From: Kari Parsons
Sent: Friday, March 17, 2023 1:13 PM
To: PCD Hearings
Subject: FW: Opposition to the latest revision of Jaynes' Property Sketch Plan skp225

From: Anthony Hicks <tony.hicks@att.net>
Sent: Friday, March 17, 2023 10:28 AM
To: Kari Parsons <kariparsons@elpasoco.com>
Subject: Opposition to the latest revision of Jaynes' Property Sketch Plan

I just had a chance to review Classic Homes' latest revision of the Jaynes' Property Sketch Plan and I am still objecting to the steepness of the transition step-down area adjacent to Highland Park 3 and part of Poco Rd area.

## SKETCH PLAN

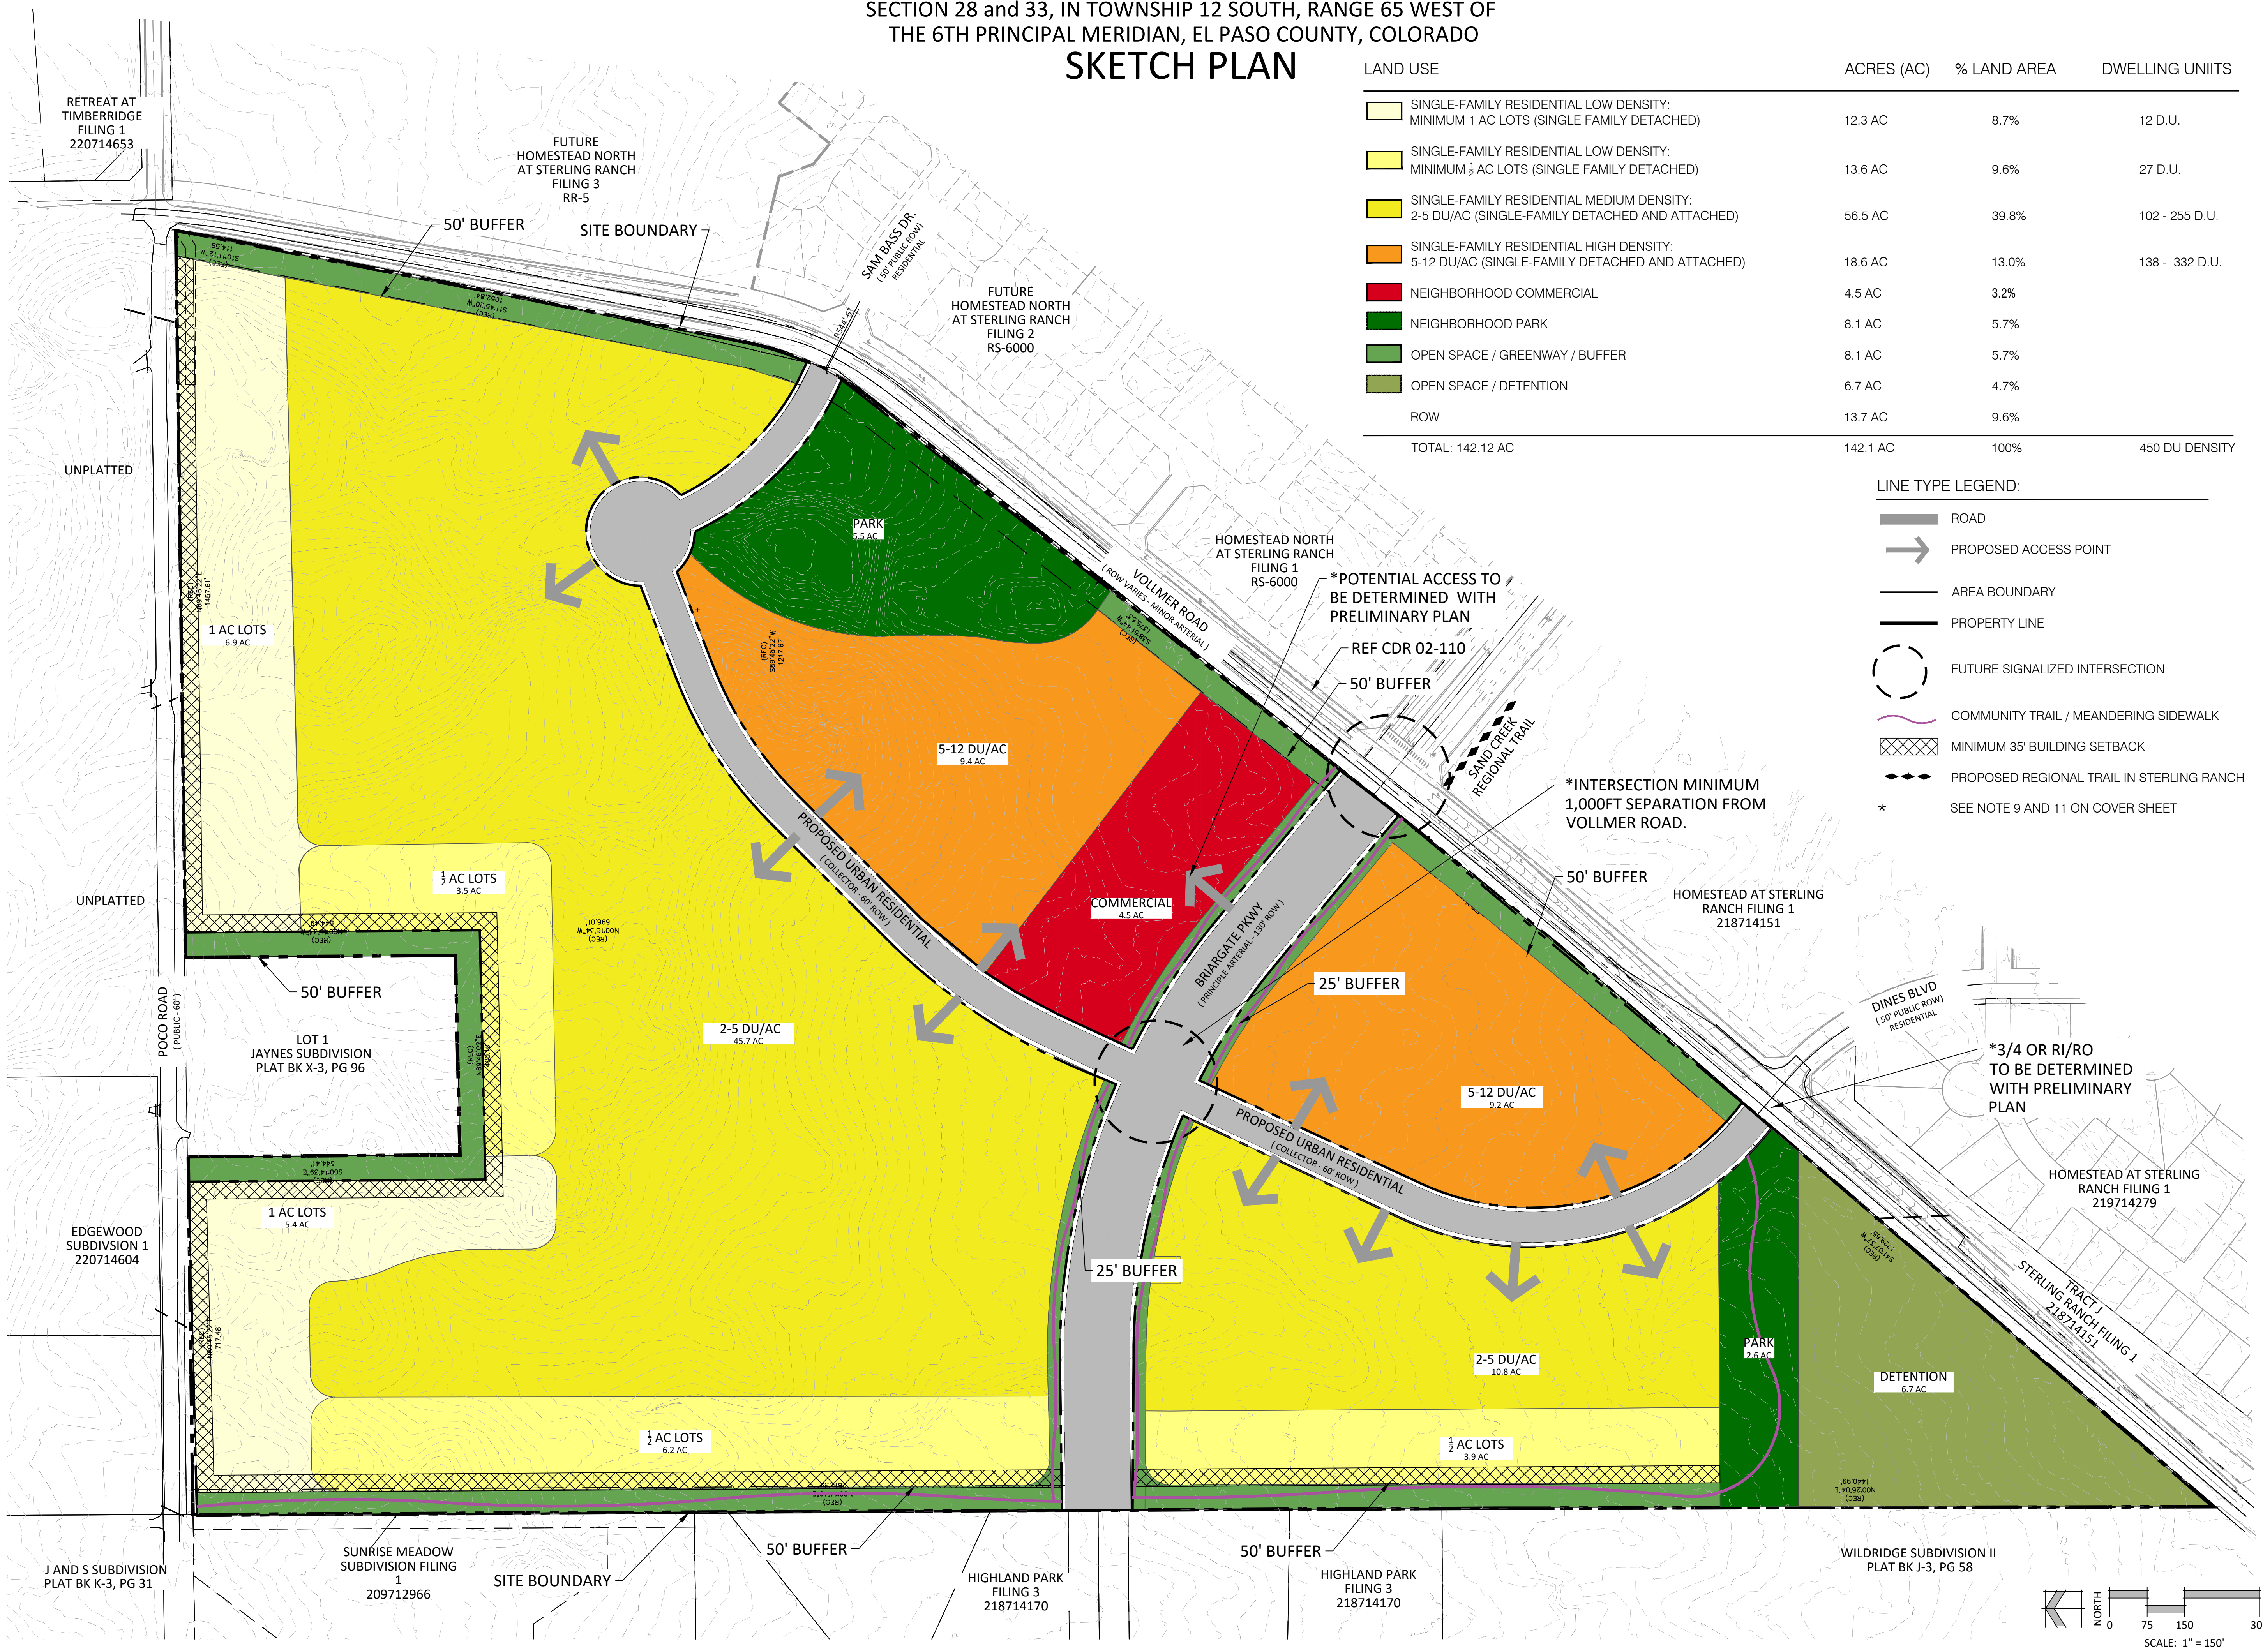
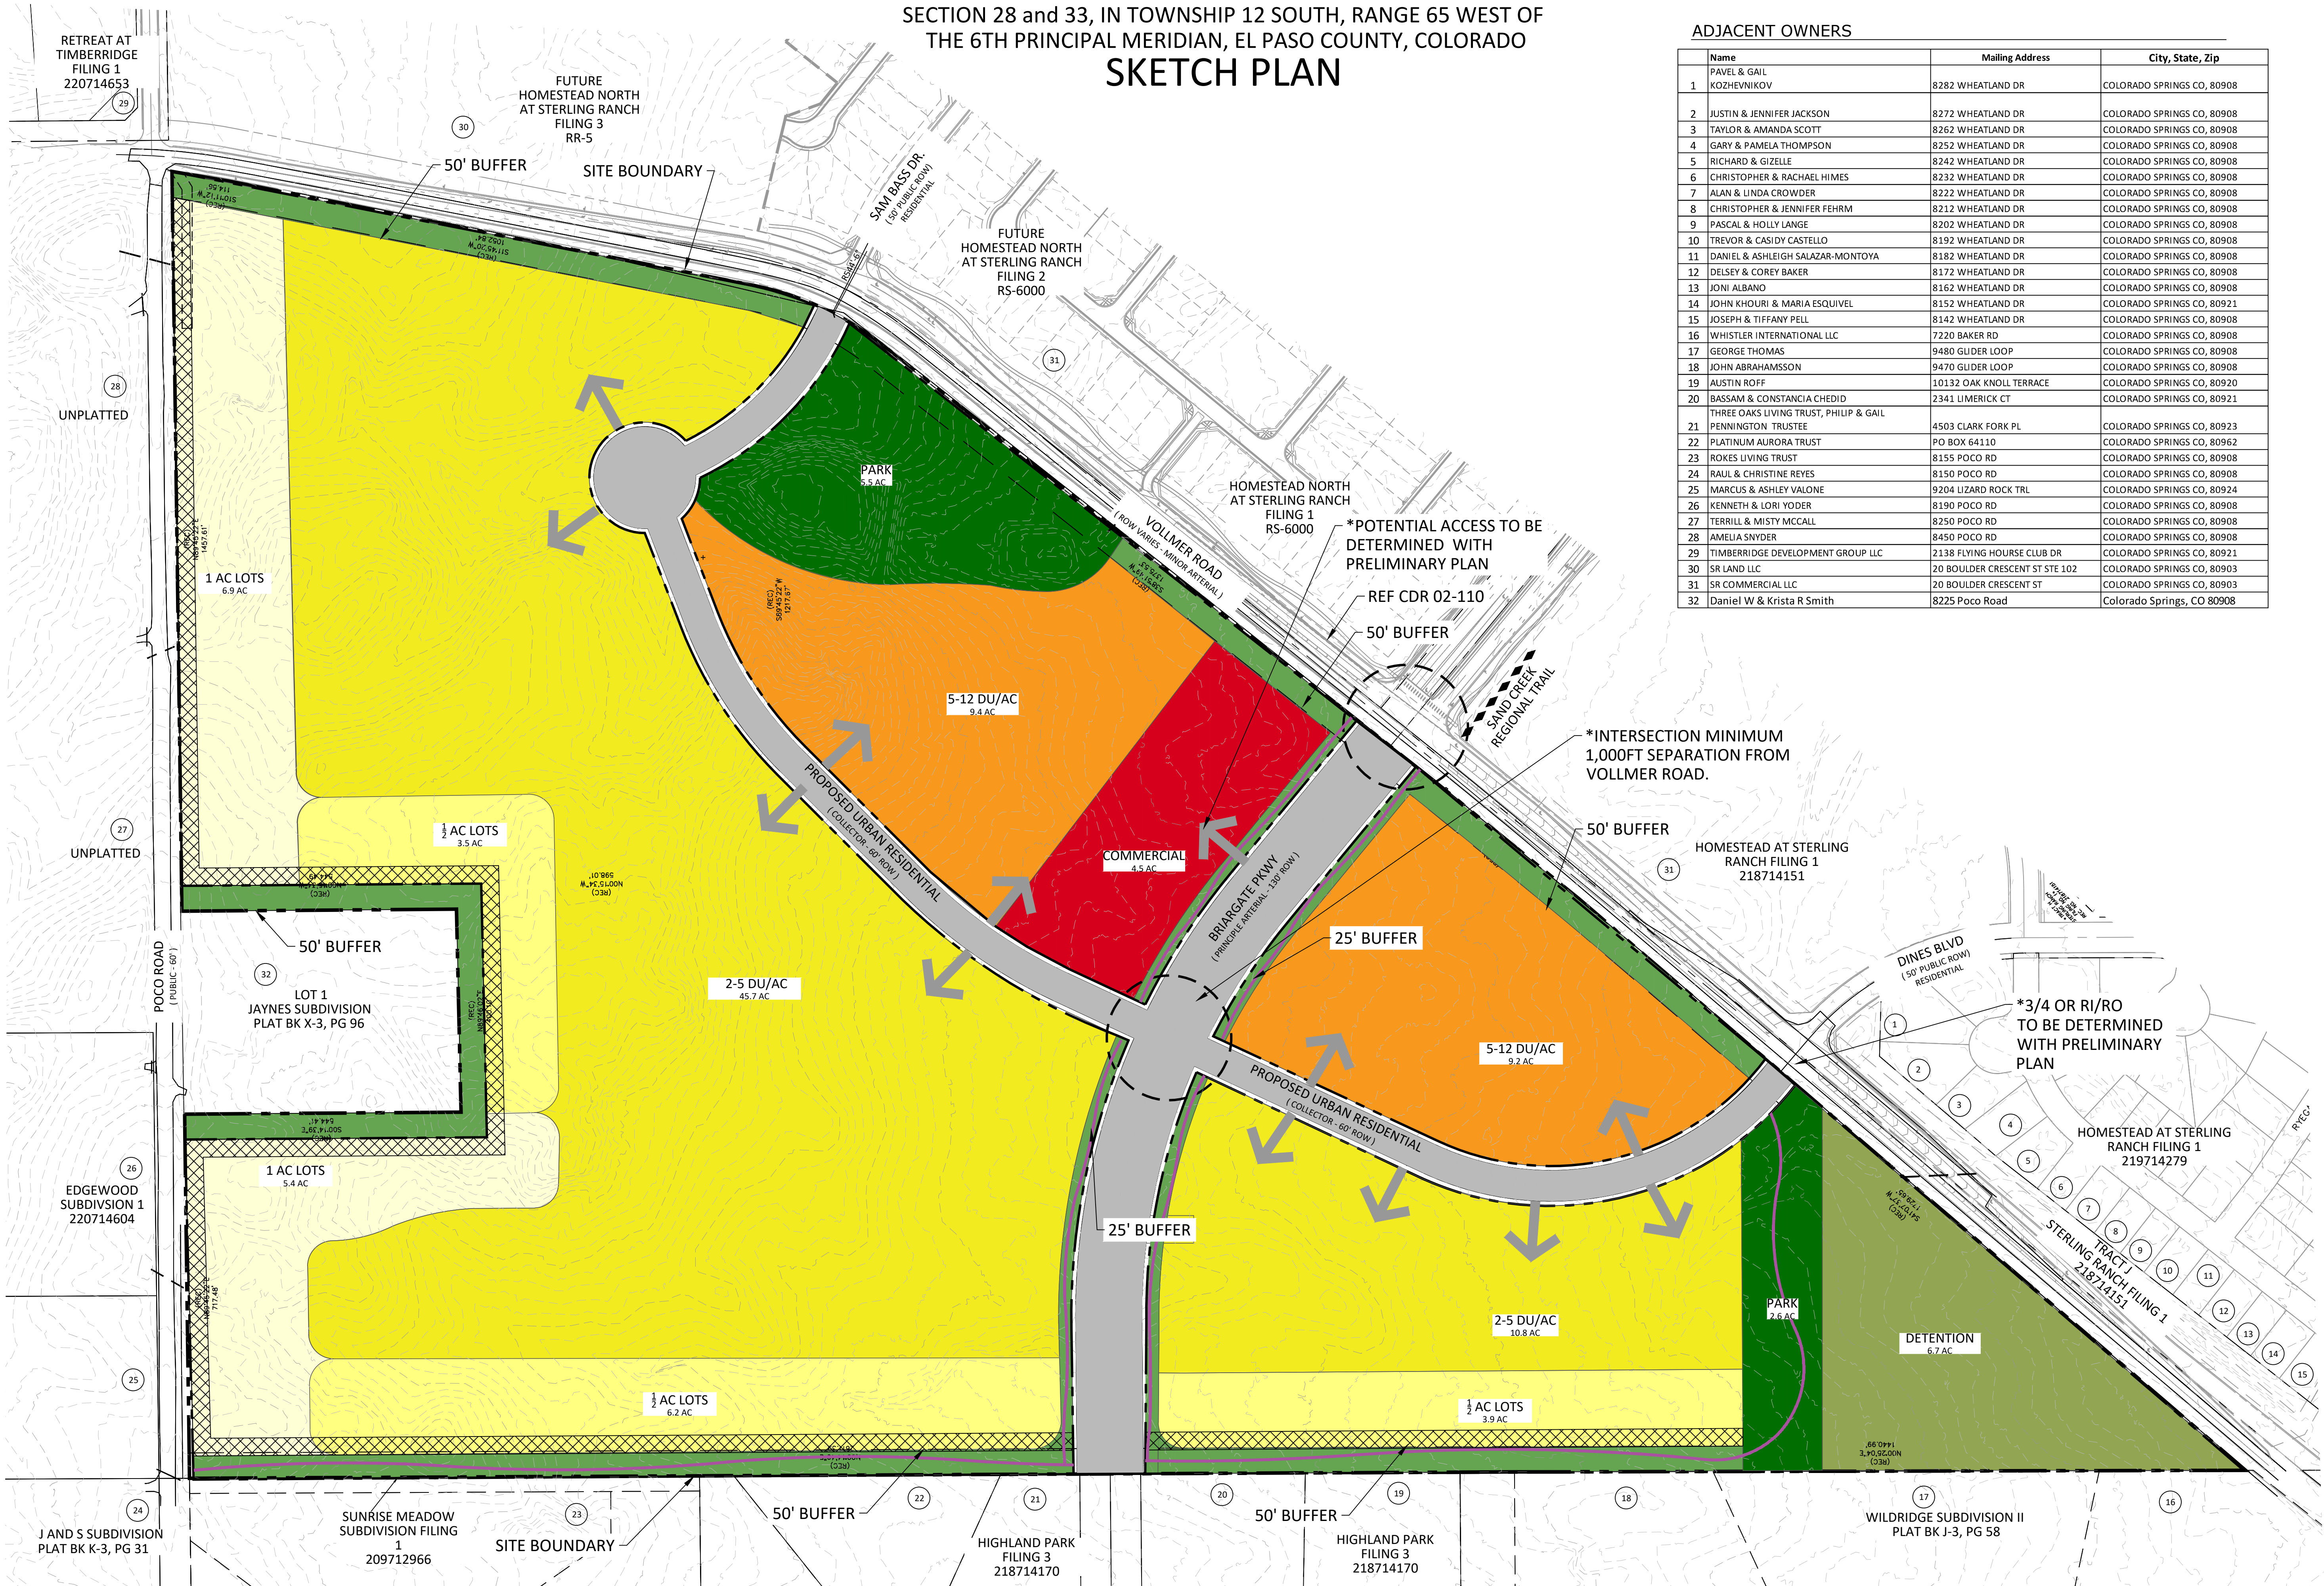
Stepping down from RR5 to 2.5 acres in their latest revision for south of Poco road is acceptable which represents a 50% down transition. But to go from RR2.5 to 0.7 acre is too steep which is a 72% drop down and that is not a transition. It is still a cliff, especially for me coming from 5 acres (a combined parcel of two RR2.5 parcels) which is a 86% drop down.

To be consistent with their new revised transition for south of Poco Road, they should also change the transition area to 2.5 acres for part of the Rokes' parcel and for me (Platinum Aurora Trust).

However, if they can at least meet the recommendation from the Black Forest Land Use Committee in December 2022 for 1-acre lots adjacent to Highland Park 3, and that could be a REAL transition. The current proposal does not qualify to be called a transition from Highland Park 3.

In addition, Classic Homes should install a 6-foot wall around their new development border for a good separation from Highland Park 3.
